**Planning application no.: 3.24.446**

**Location: New Springs Barn, Saccary Lane, Mellor**

**Proposal: Proposed conversion of attached garage to home office and utility room, construction of detached double car port and garden wall.**

Proposed Detached Carport Layout

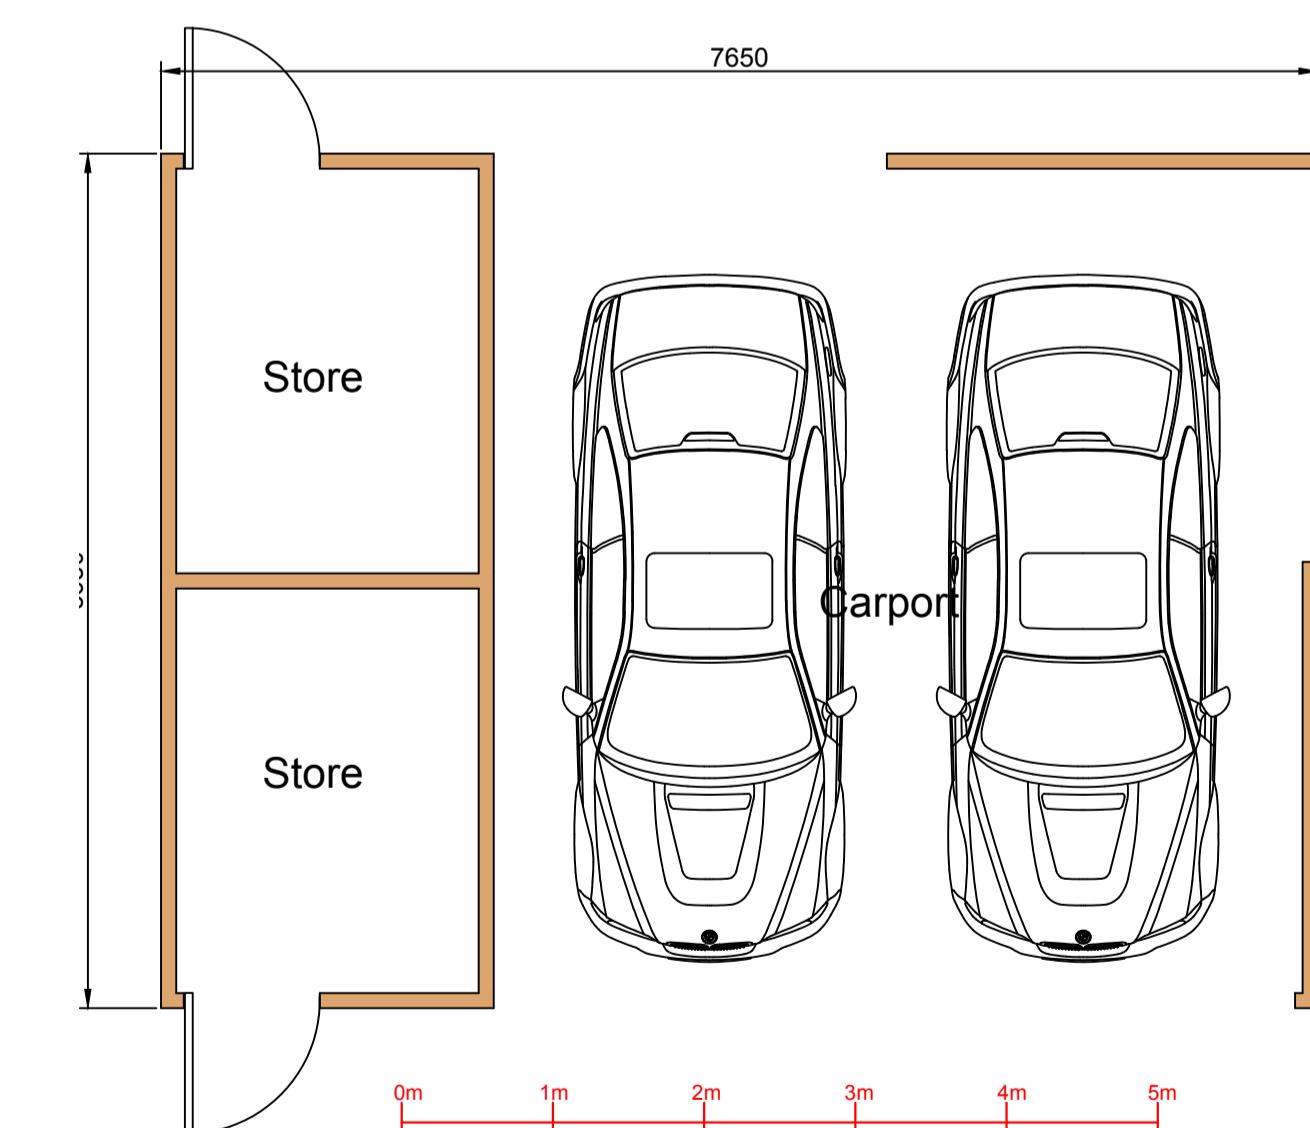
Further to the additional information (photos of the proposed wall), Photo 8, the new garden wall needs to be set back in the same position of the current hedge and ensure that the paved strip is left as is. This is needed for improved visibility.
